Our Case Number: ABP-314724-22

Re: Railway (Metrolink - Estuary to Charlemont via Dublin Airport) Order [2022]
Metrolink. Estuary through Swords, Dublin Airport, Ballymun, Glasnevin and City Centre to
Charlemont, Co. Dublin

OBSERVATION LETTER

Application Title: Metrolink

MATER STATION

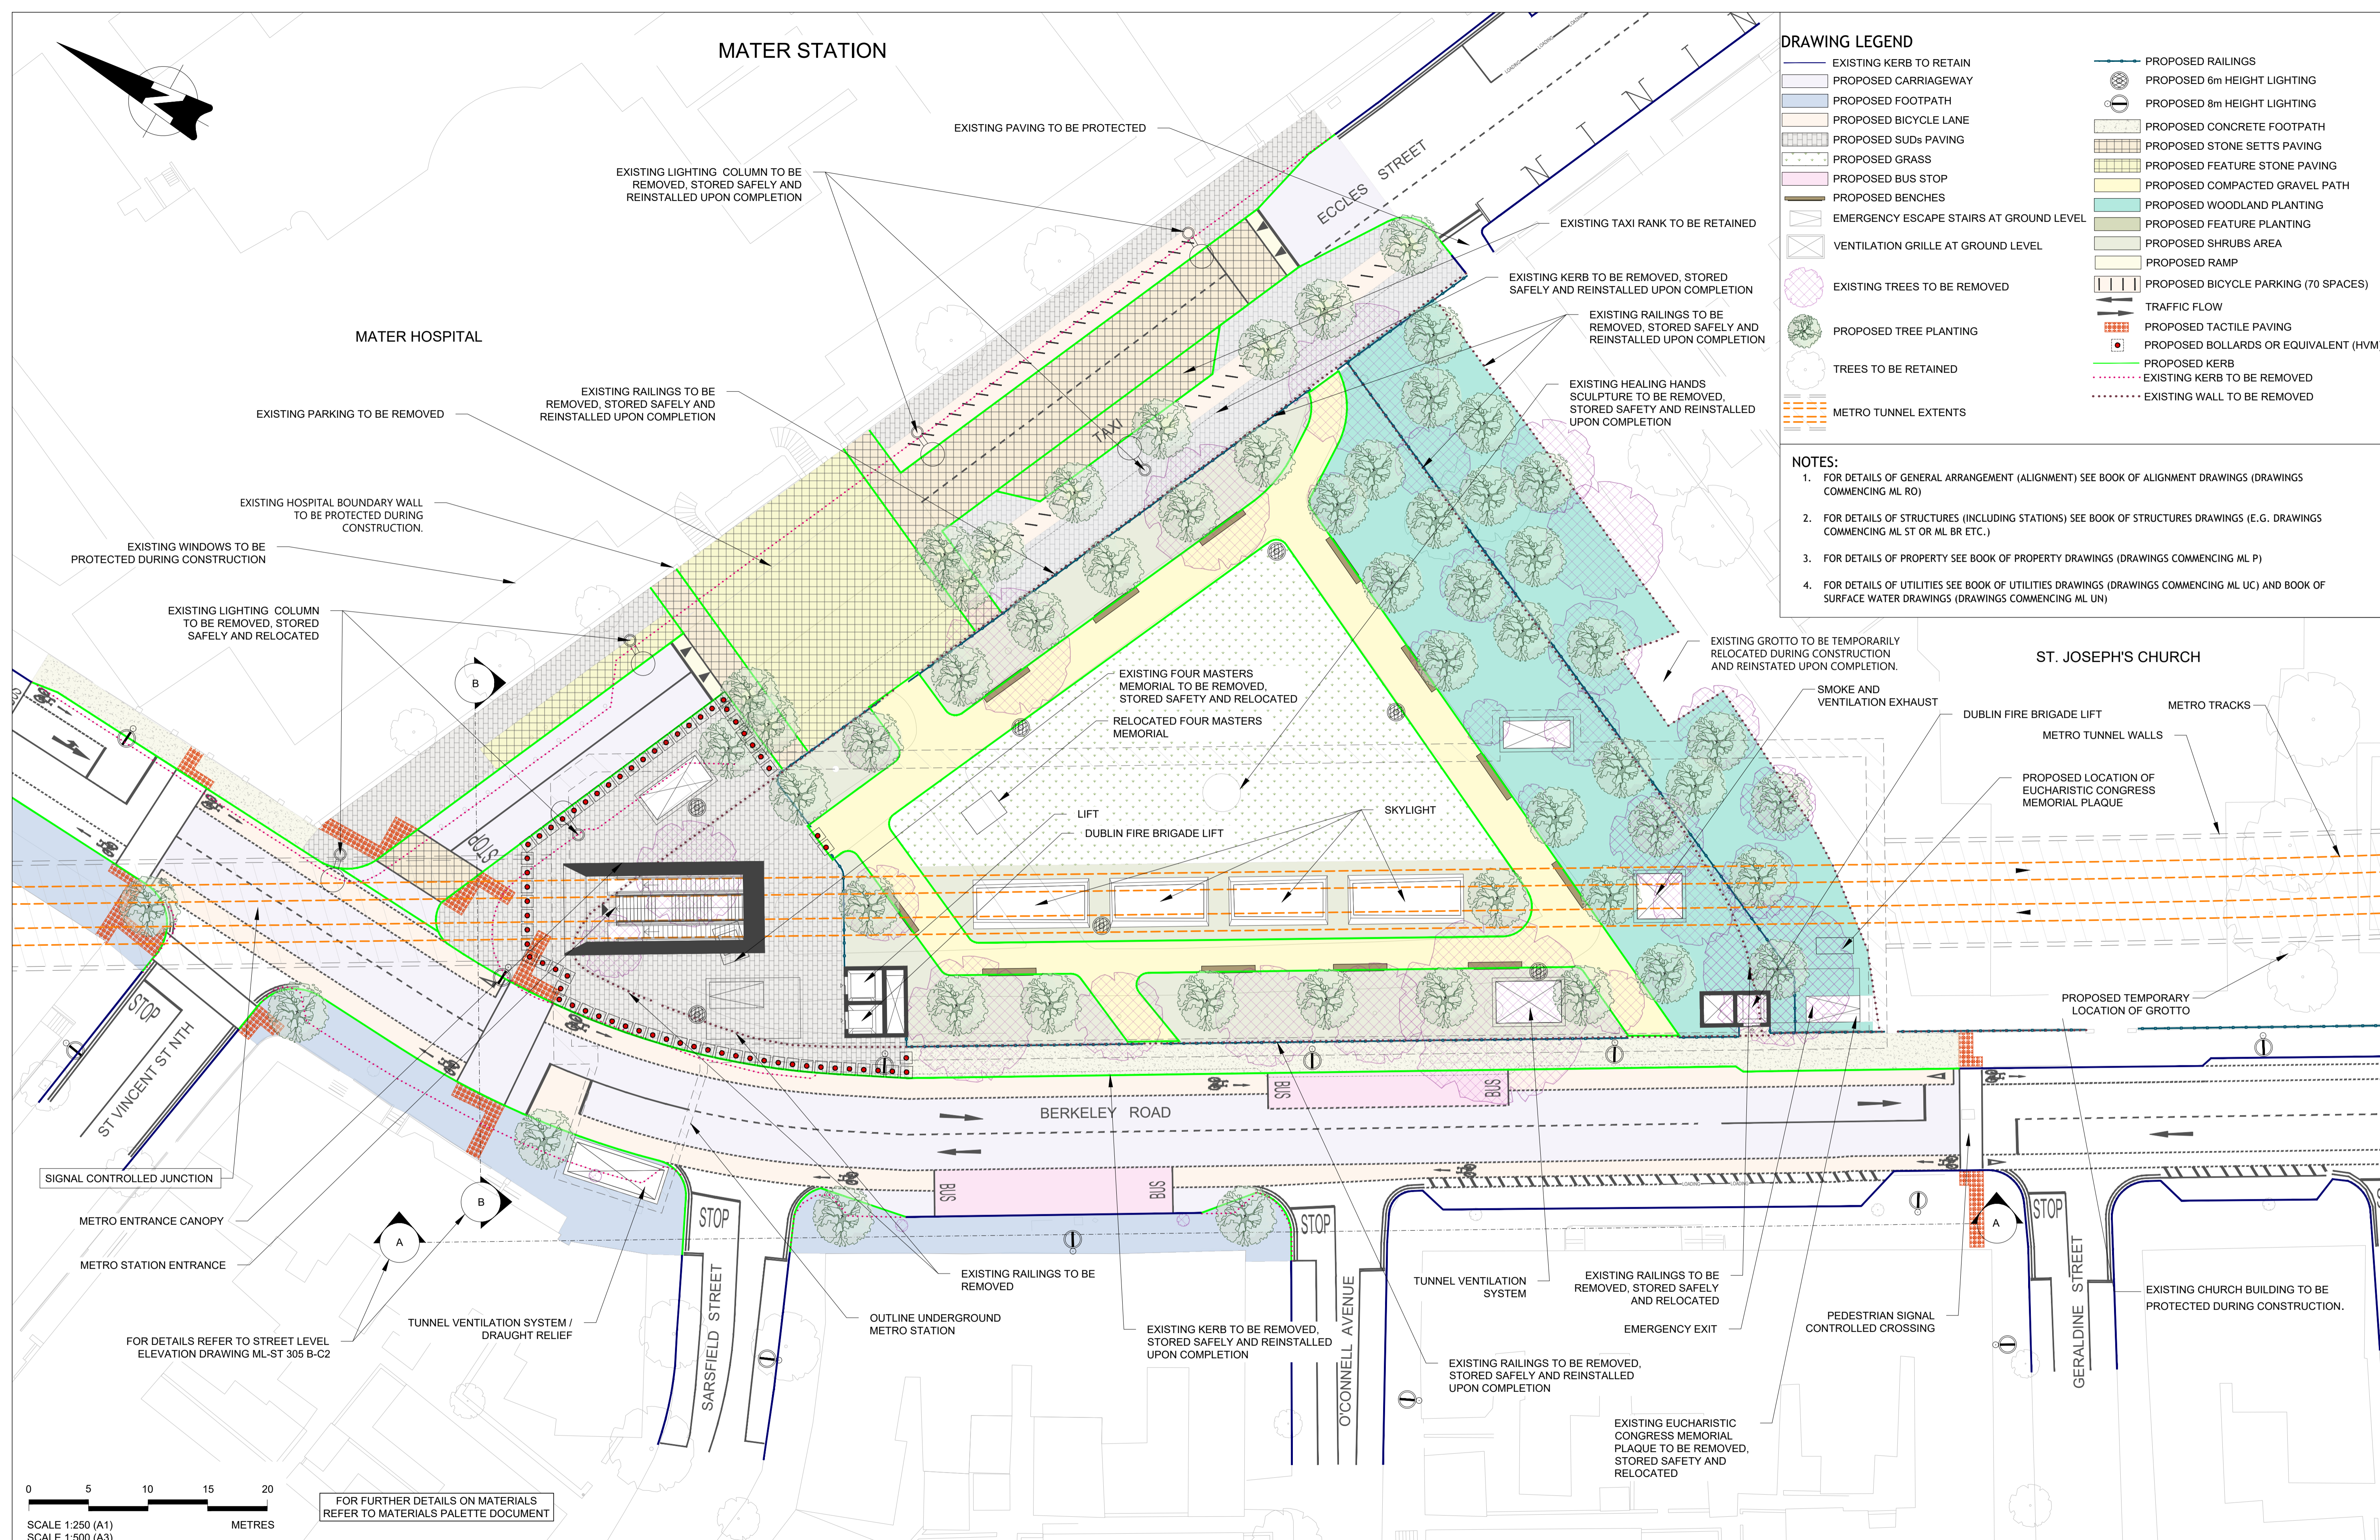
We have stated from the very beginning that the design and scale of the overground structures, which include the station entrance portal, the passenger and fire brigade lifts are out of keeping with their location in a historic urban parklet (Four Masters Park). The design of these features as currently planned has no support from local residents. Considering the prominent location of these modern structures, which will be in the line of sight of historic Protected Structures and streetscapes, their design should be more sensitive to and in keeping with the local urban fabric.

1. That a serious attempt be made to redesign the station's entrance portal in order that it is less dominant. (For example, the iron frame of the station entrance portal could be reduced in width and that the glass used should be clear and not tinted so as not to obscure the vistas towards the surrounding architecture.)

2. That the visual impact and bulk of the Passenger and Dublin Fire Brigade lifts similarly be redesigned to soften their impact and that they be clad in a material more sympathetic to the surrounding historical architecture.

3. That the steel bollards around the perimeter of the station are out of keeping with the historic environment of the area. We request that these be of granite rather than polished steel to match the granite plinths of the railings and granite kerbing. It is stated that 'Treatment of bollards and how they integrate with the environment will be agreed with the local authorities and other relevant stakeholders.' This has been agreed for the Stephen's Green Station (see 'Hostile Vehicle Mitigation') and should be provided for the Mater Station to blend in with the existing use of granite in railing plinths, kerbing and architecture around the park and in the use of granite in the plinth for the station entrance portal. It is also not clear how far south along Berkeley Road the bollards run along the footpath. We require clarification on this.

4. The amount of paving is excessive - there are too many hard surfaces - turning the Park into an open plaza (similar to that at Broadstone Plaza). Experience at the latter site shows that this attracts skateboarding, broken glass and discarded litter (including chewing gum). It also prevents water permeability, especially during periods of heavy rain - there are already instances of pooling of water after heavy rainfall along Eccles St near St Joseph's Church and at Berkeley Road near the former McSweeney House. We request that, in keeping with the Sustainable Urban Drainage Systems described in the Dublin City Development Plan, this issue be addressed by TII and that some raised beds be introduced into the paved area around the entrance portal to soften the effect of the paving.
